Recommendation Report for Planning Permission for Works or Extension to a Dwelling

REF NO: A/145/25/HH

LOCATION: 8 Lloyd Goring Close
Angmering
BN16 4LQ

PROPOSAL: Two storey side and single storey rear extension.

PROPOSED ELEVATIONS

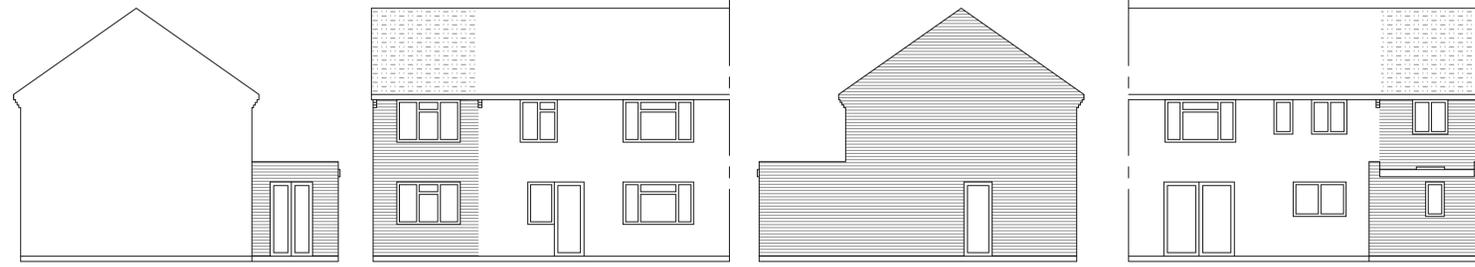
The proposed two storey side extension would adjoin the eastern flank elevation of the dwelling and would measure 3m in width, 6.5m in depth and would have an eaves height of 4.6m, matching the existing eaves, and a maximum height of 7.2m, adjoining the existing ridge height. Section M.01 of the Arun Design Guide (ADG) specifies that side extensions should be set back from the front elevation and down from the ridgeline by a minimum of 0.5m. The height of the proposed extension would be equal to the ridge height of the existing dwelling, and the extension would not be set back from the principal elevation, thus the extension would not strictly accord with this section of the ADG. According to the ADG, side extensions should respond to building design in terms of roof pitch and use complementary and integrated materials and elevational design. The proposed extension would integrate well with the existing dwelling as the extension would retain the character of the property by featuring matching materials to the existing dwelling and the extension would have a pitched roof form, reflecting the existing dwelling. As such, the extension would not appear out of place within its context as it is noted that there are several examples of side extensions within the wider street scene, including at Nos. 2 and 28 Lloyd Goring Close. The roof of the extension would integrate well with the host dwelling and would not appear unduly prominent within the street scene. As such, the proposed two storey side extension would not result in harm to the character of the host dwelling or street scene.

No fenestration is proposed within the first floor level of the eastern flank elevation of the side extension. Two windows are proposed within the front (north) elevation which would give rise to views onto the street and would not be significantly different to those achieved from the existing front windows. Two windows are proposed within the rear (south) elevation which would give rise to views of the rear garden. Due to the close proximity of the additional first floor window serving an en-suite within the rear elevation and resultant additional perceived overlooking, a condition has been attached to this planning permission

- 3 The window at first floor level within the rear (south) elevation of the building shall at all times be glazed with obscured glass to a level equivalent to Pilkington Level 3 or nearest equivalent standard and be non-openable below 1.7m above finished floor level. This arrangement shall be permanently retained thereafter.

PROPOSED GROUND FLOOR PLAN

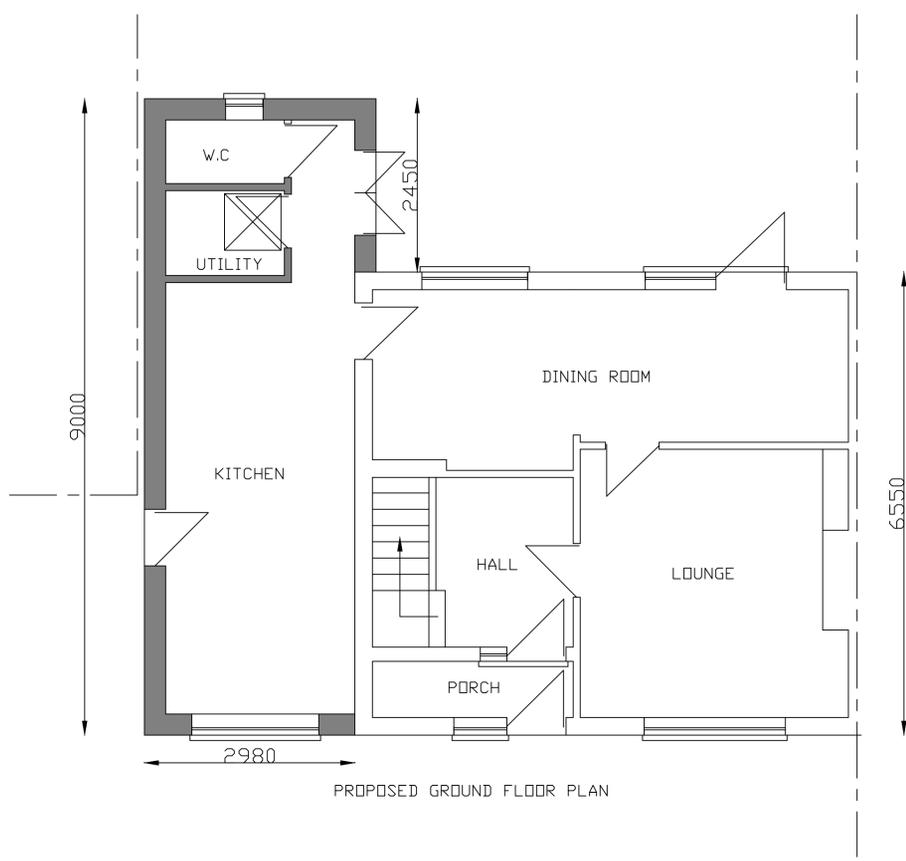
The proposed single storey rear extension would measure 2.5m in depth and 3m in width. It would have a flat roof form with a parapet and a maximum height of 2.8m. A lantern rooflight is proposed within the flat roof of the rear extension. The extension would partly replace an existing garage and utility room and

it would comply with the Arun Design Guide (ADG) which sets out that the depth of single storey rear extensions to semi detached dwellings should not exceed 3.3m. The proposed rear extension would not result in harm to the character of the dwelling.

The application site has neighbours on both sides and to the rear. The proposed rear extension would maintain a distance of approximately 6.1m to the rear boundary. The rear extension would replace an existing structure and would not increase the footprint any further to the side or rear boundaries. The flank-to-flank distance of the single storey extension with the east neighbour, 10 Lloyd Goring Close, would be 9.3m. Given the rear extension would replace the existing structure, it would not result in any harm by way of overbearing or overshadowing impacts to the neighbour to the east.

PROPOSED FIRST FLOOR PLAN

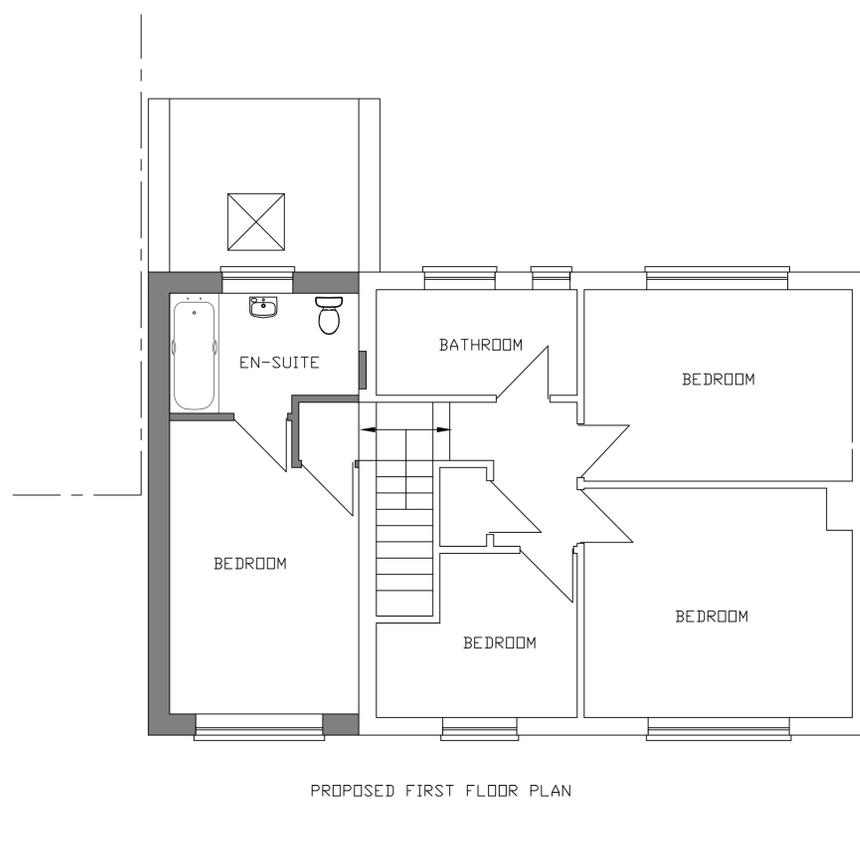
to require this window to be obscurely glazed and non-opening below 1.7m above the internal floor area to prevent unacceptable perceived and actual overlooking from occurring.
